HUHN, KEN, 3/7/2024 6:37 AM

GRANDVIEW RESERVE PHASE 2 PUD DEVELOPMENT PLAN & PRELIMINARY PLAN

NOT FOR CONSTRUCTION
 LAND USE REVIEW FILE NO: PUDSP-23-006

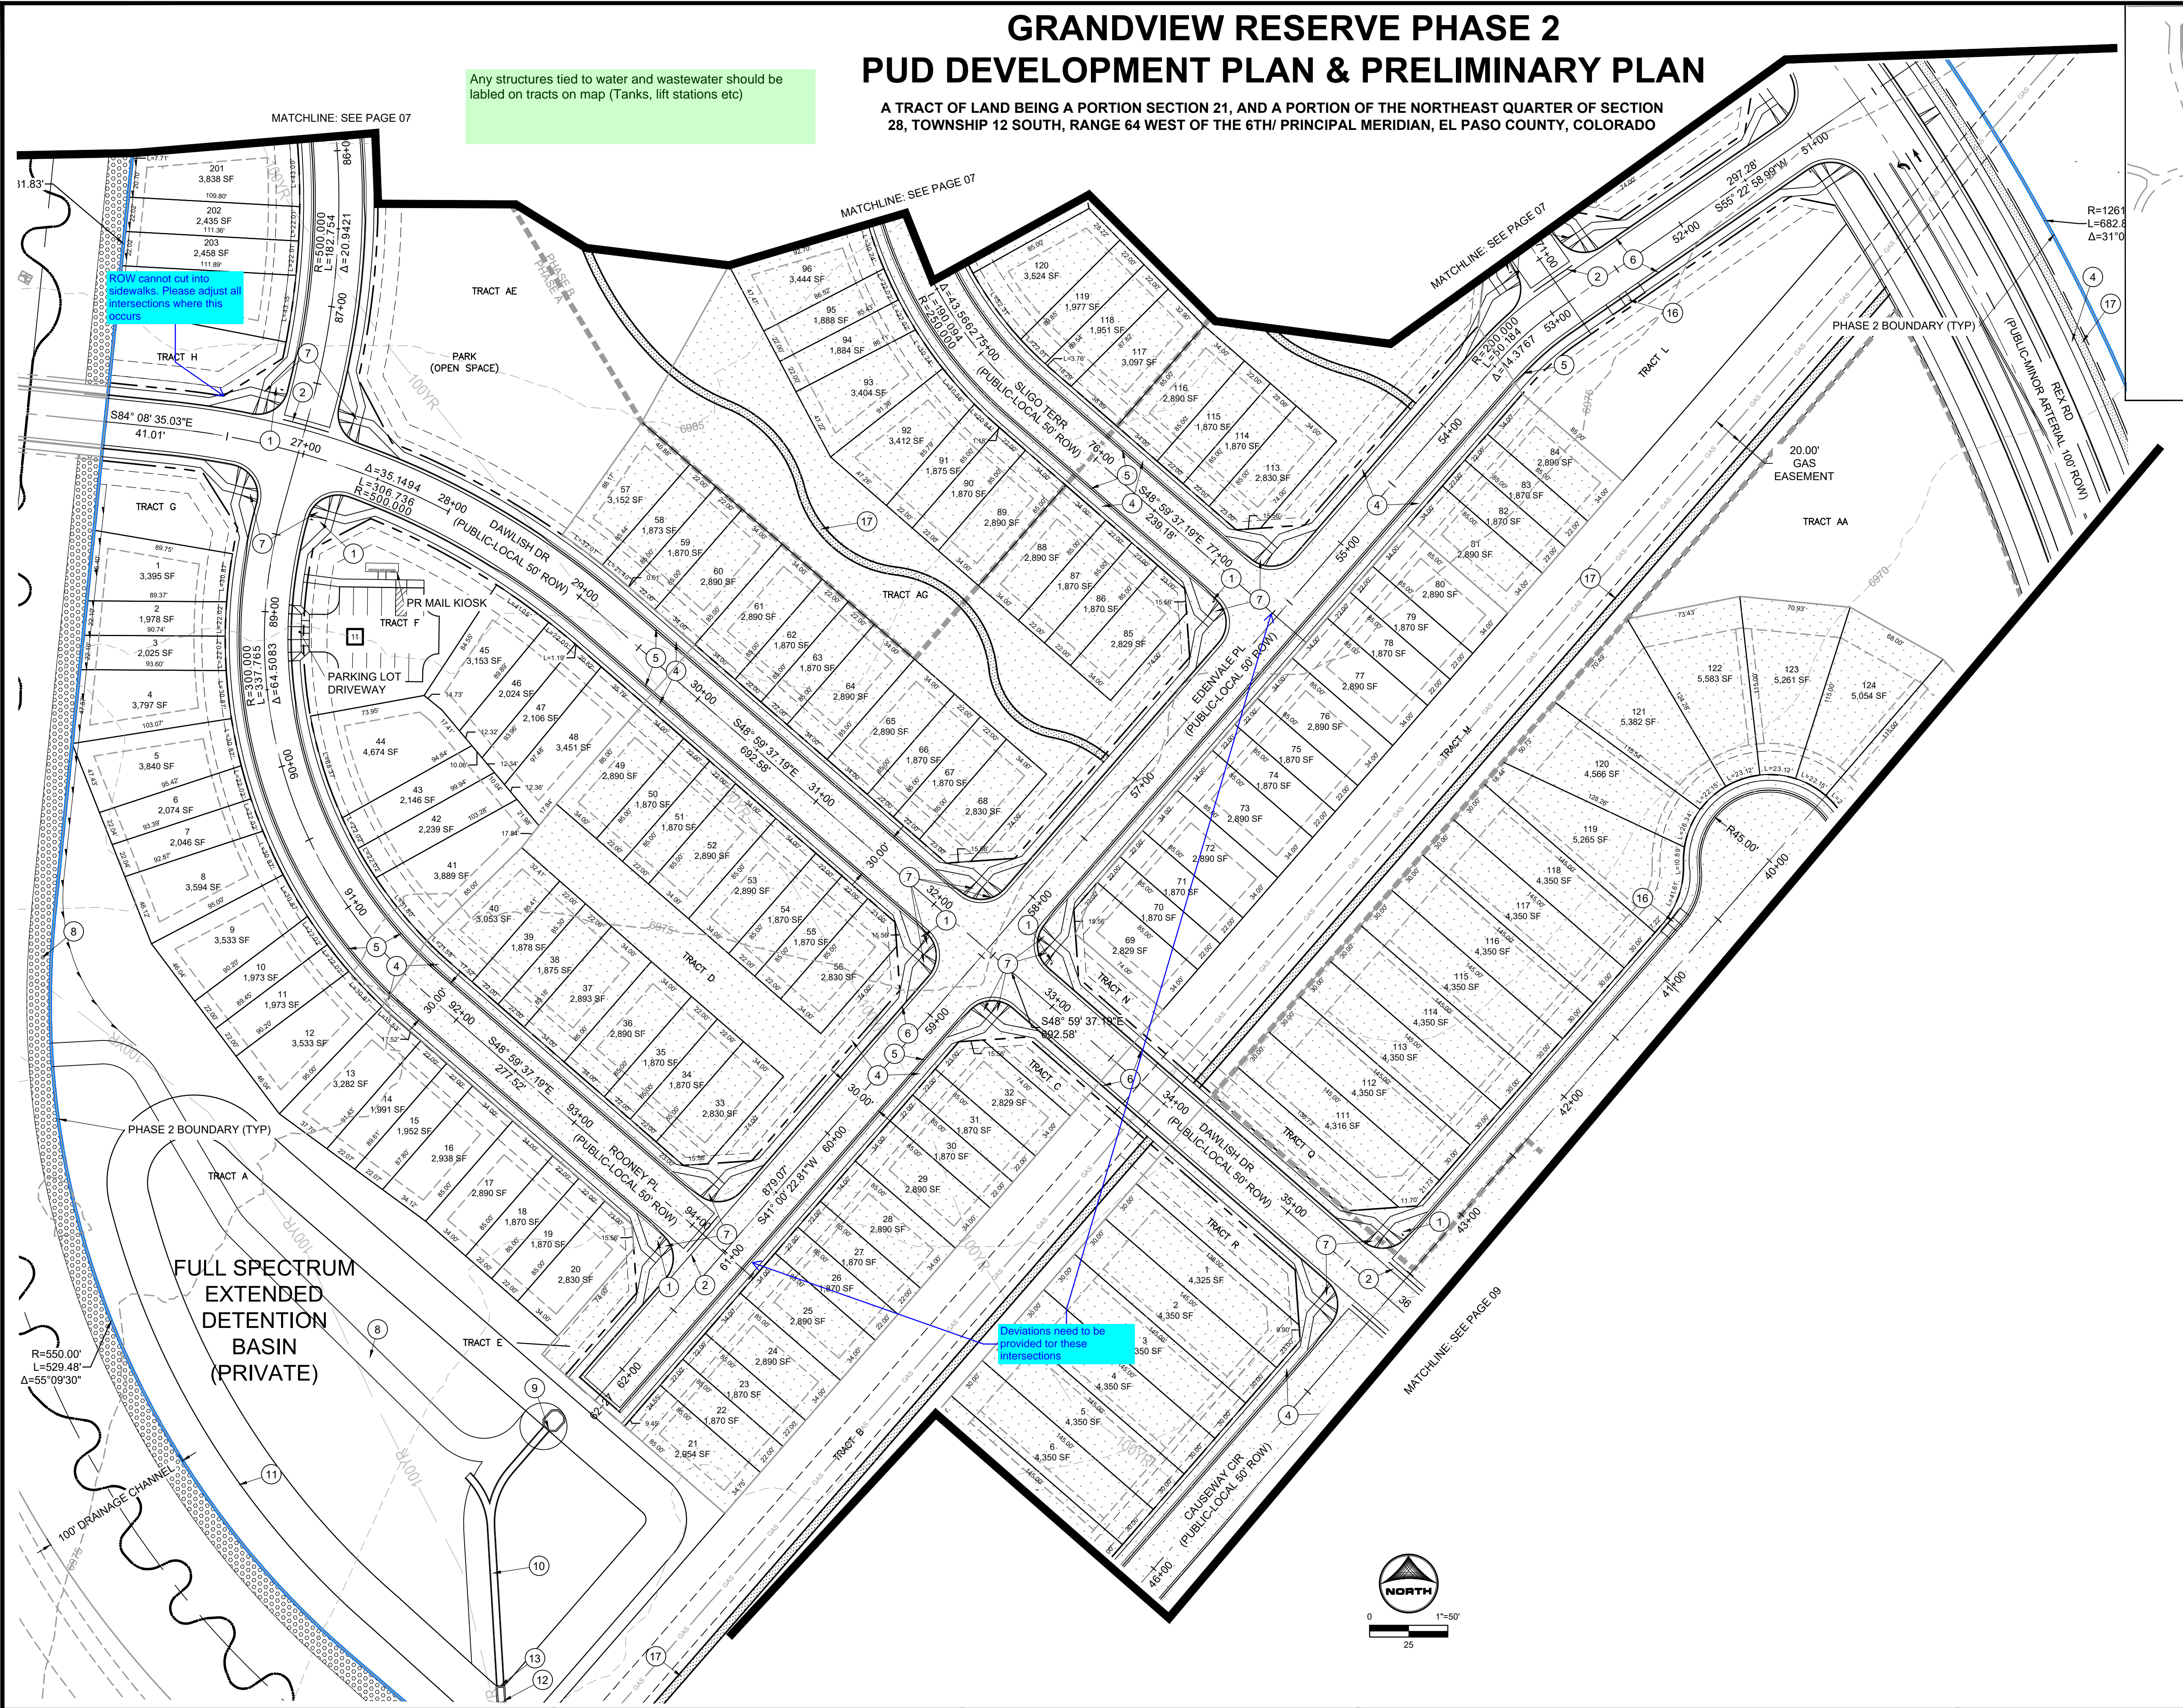
Any structures tied to water and wastewater should be labeled on tracts on map (Tanks, lift stations etc)

ROW cannot cut into
sidewalks. Please adjust all
intersections where this
occurs

Deviations need to be
provided for these
intersections

HRG RESPONSE
WATER STORAGE TANK
LABELED ON TRACT PLAN

HRG RESPONSE
NOTED, VERIFIED SIDEWALK
DOES NOT ENCRoACH INTO
RIGHT OF WAY

HRG RESPONSE
DEVIATION PREPARED FOR
APPLICABLE INTERSECTIONS
